Your Ref: OWPC17896
Our Ref: BR/69/18/HH 06-03-2018
Please ask for:
Mr S Davis

New roof with first floor accomodation, dormer to side elevation, porch to side elevation
& single storey rear extension (revision to previously approved BR/305/17/HH).

30 Mansfield Road Bognor Regis

PROPOSED ELEVATIONS

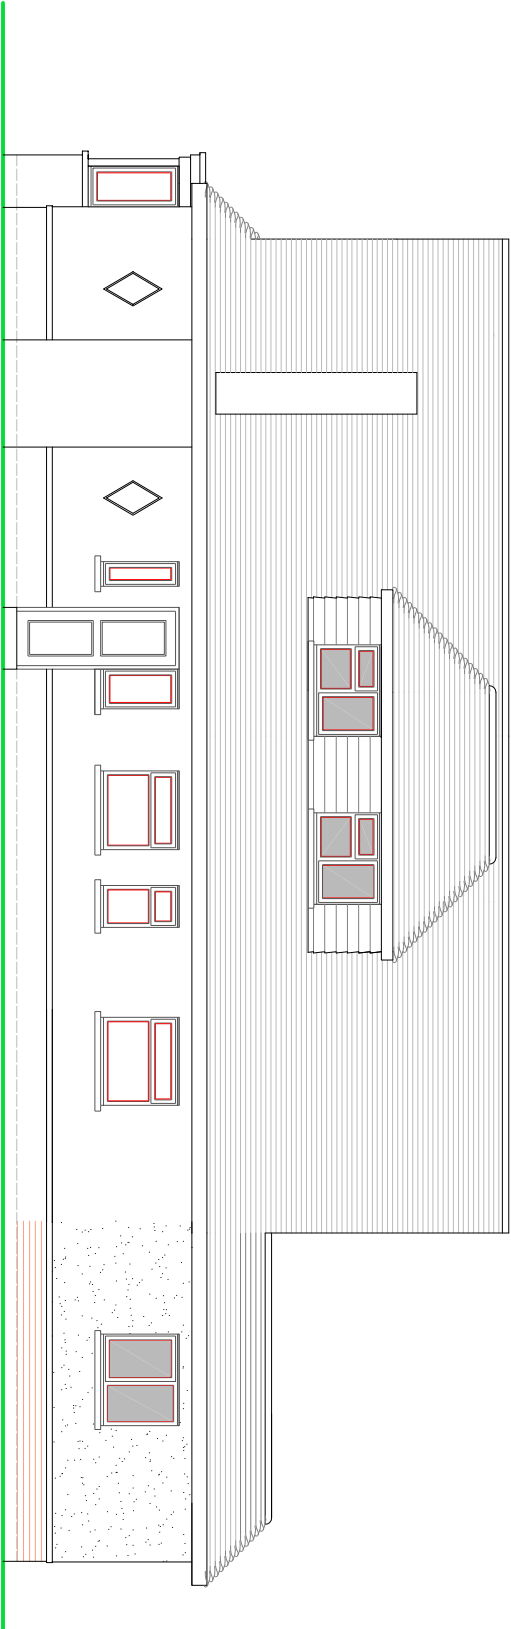
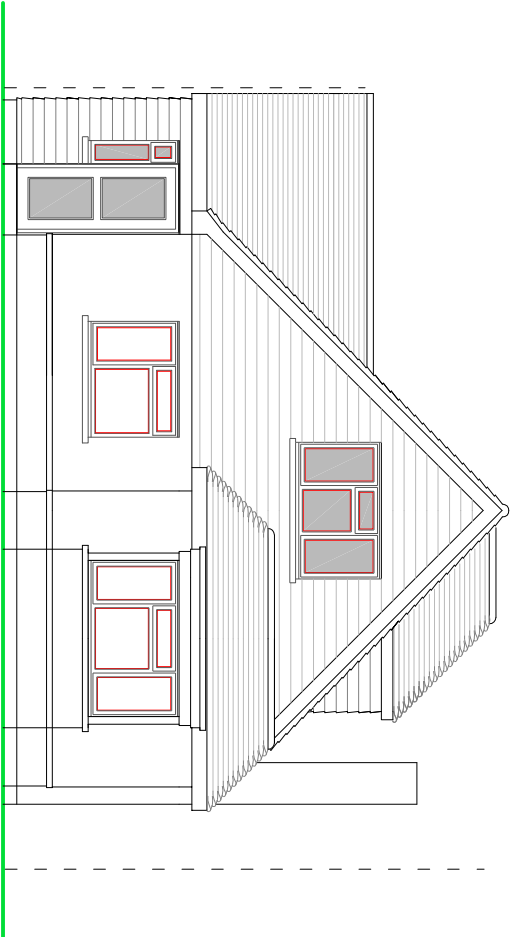
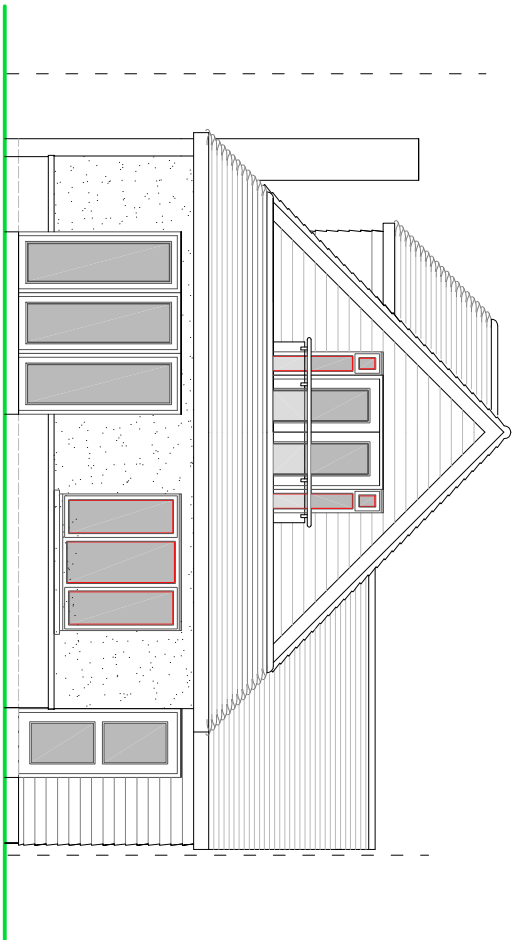
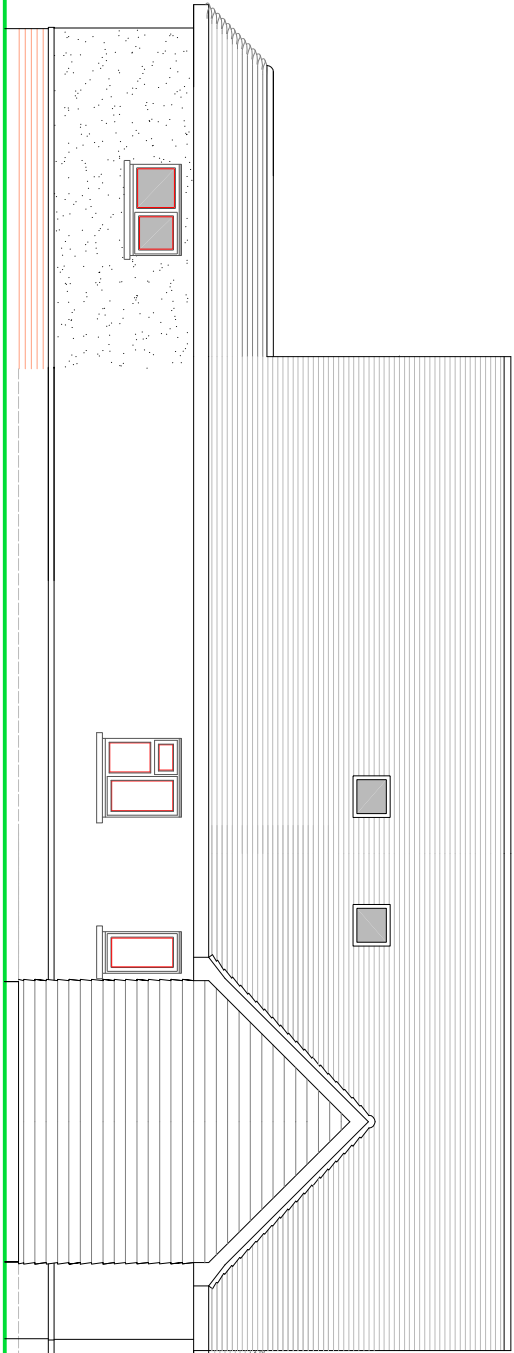
*Under the old application it was conditioned that the Windows in the South facing former
to be obscured glass and fixed shut if lower than 1.7 metres from the floor level. Please
ensure that this condition is applied to this new application.*
